CITY OF ALBUQUERQUE

April 18, 2018

RE: **10512 Redbud Residence**
10512 Redbud NW
Pad Certification Dated: 4/8/18
Grading Plan Stamp Date: 1/15/18
Hydrology File: A12D027

Based on the submittal received 4/9/18, the Pad Certification cannot be approved until the following are corrected:

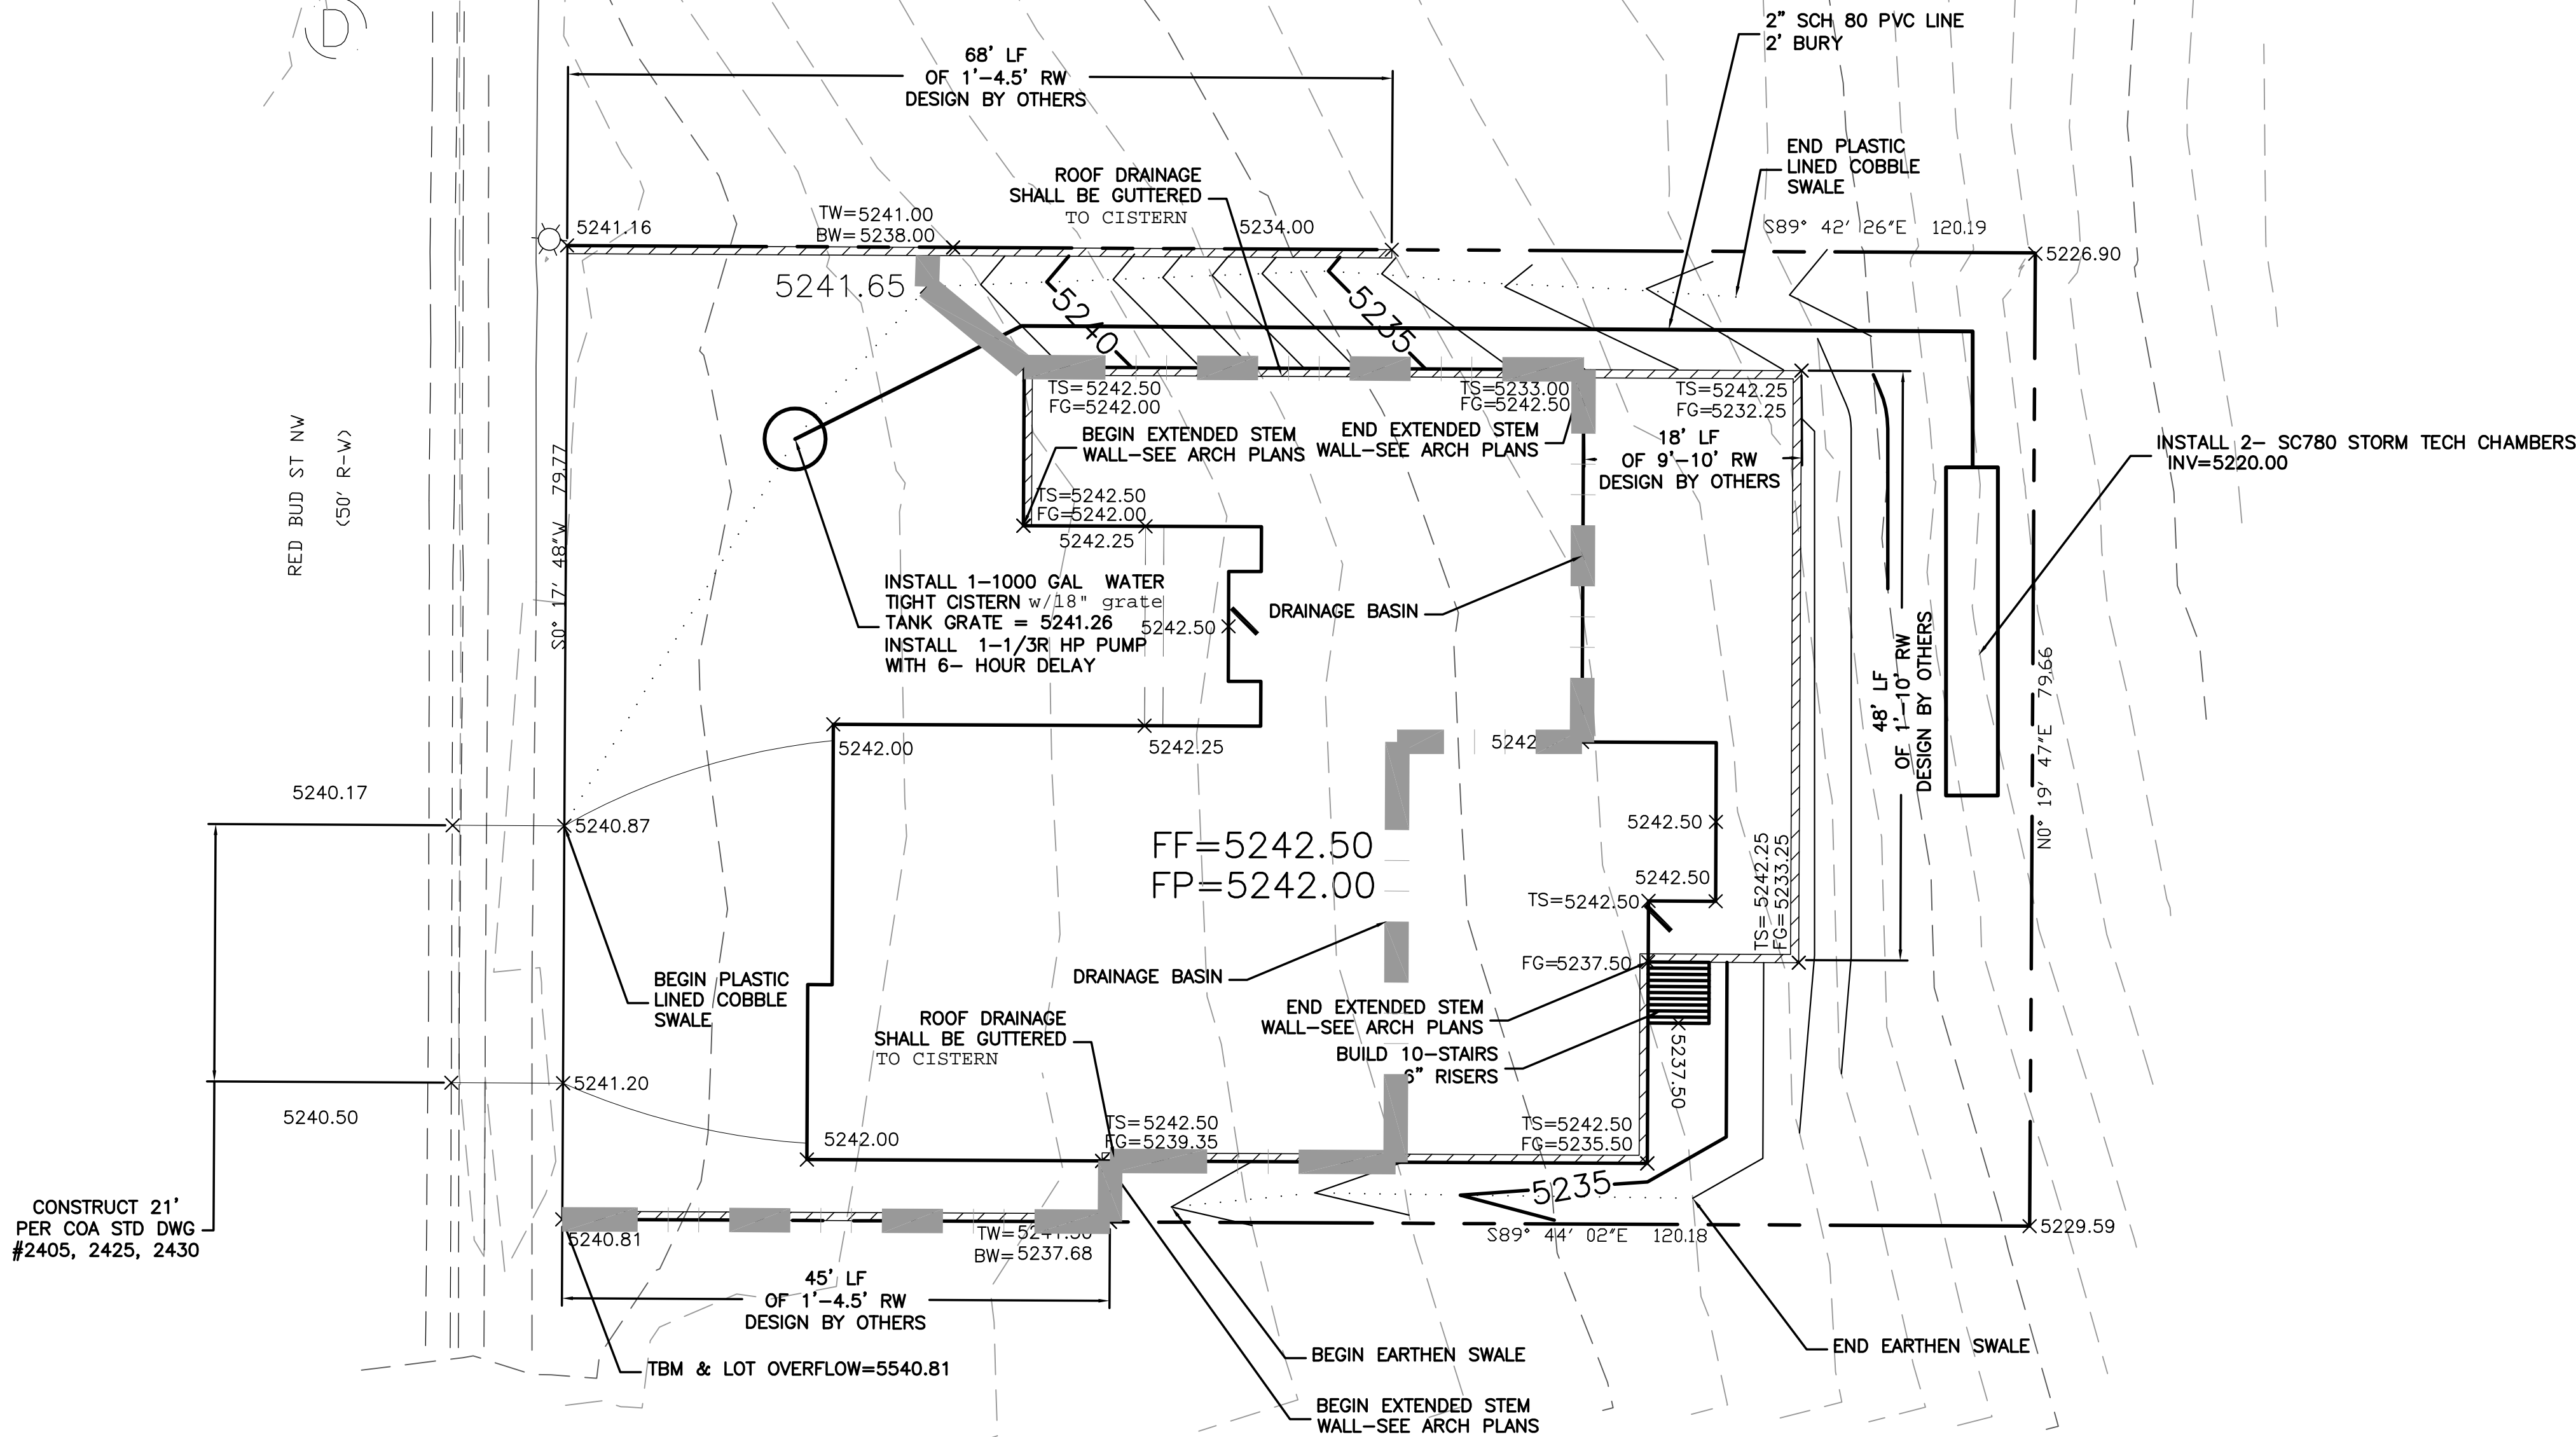
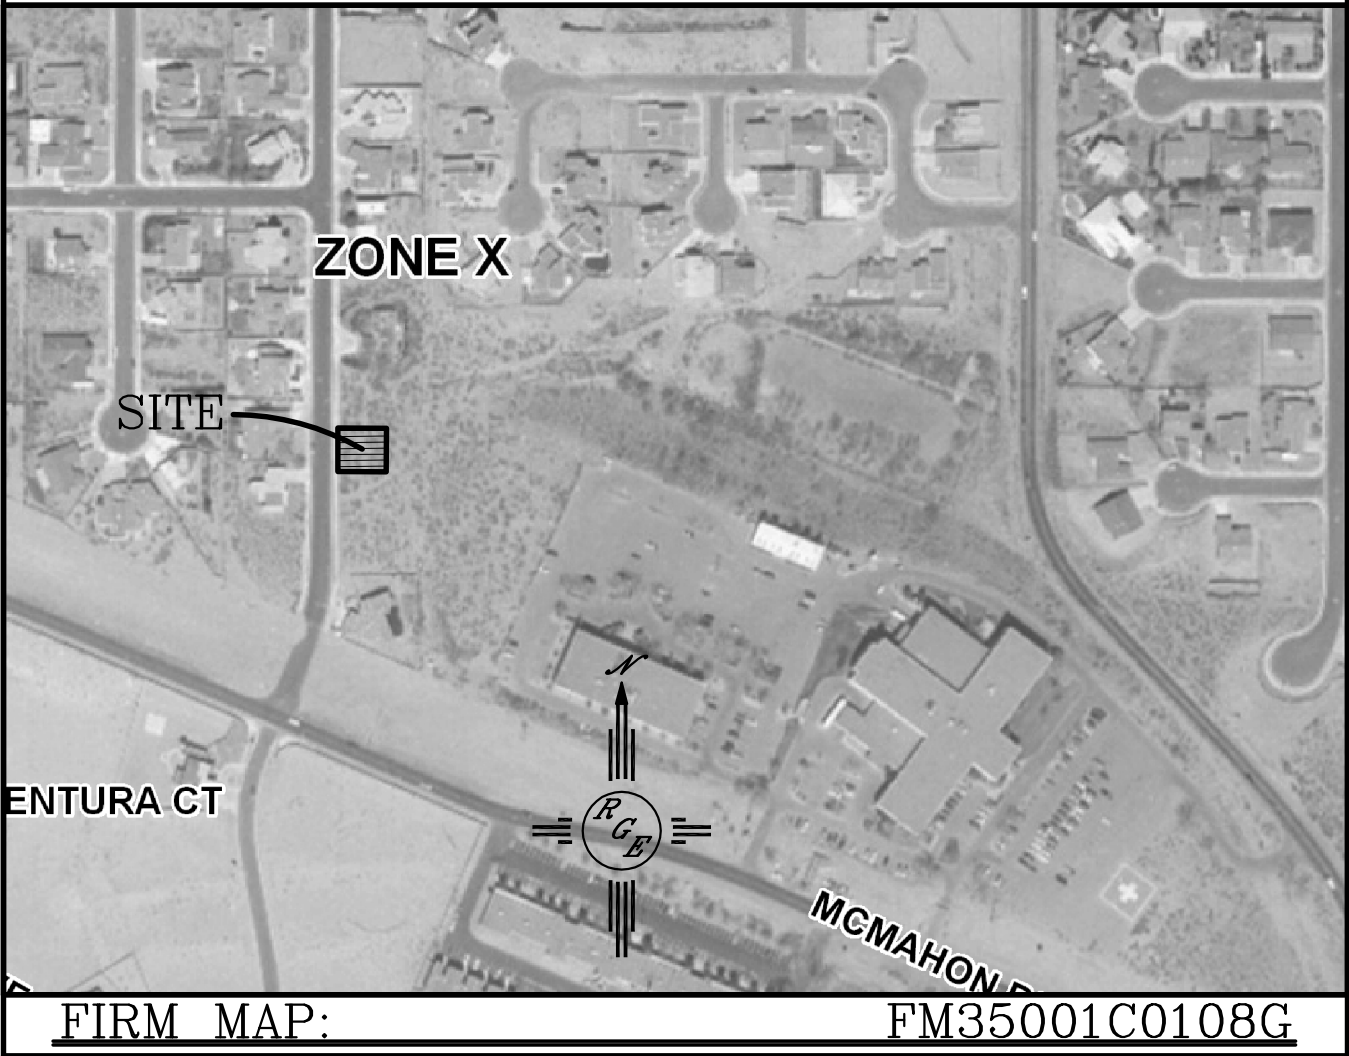
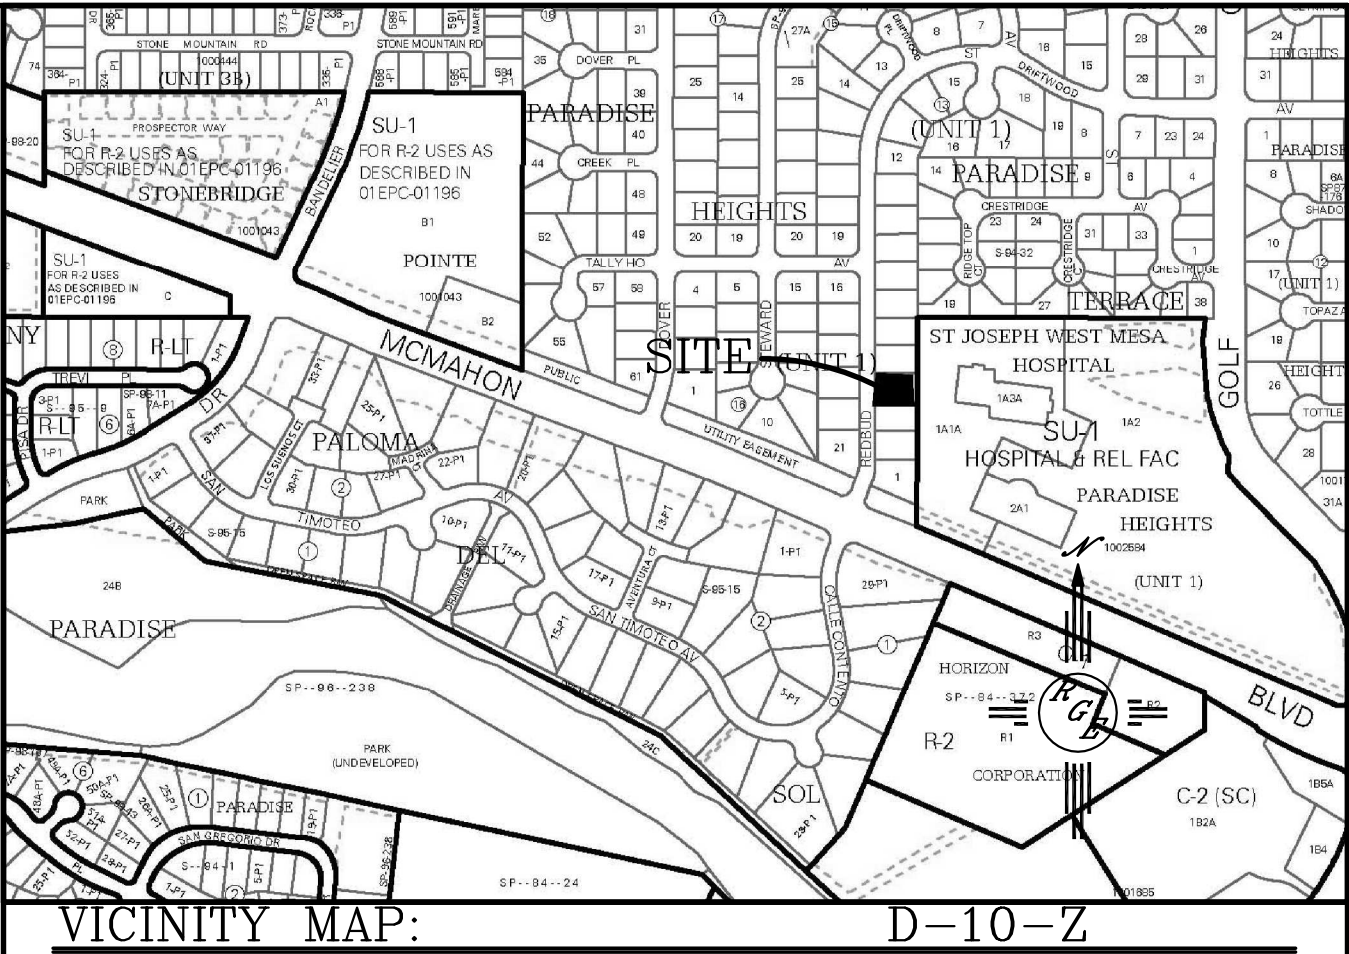
1. Provide written permission from the adjoining landowner to the south (Lot 3) for the grading on their property. This permission will need to include: permission to grade, affirmation that the undersigned is the owner of Lot 3, and owner signature.
2. A revised grading plan, showing the additional grading is required.
3. Include a reseeding and site stabilization specification for the additional graded areas that won't be developed with the subject lot. Reseeding and stabilization will be checked at C.O.
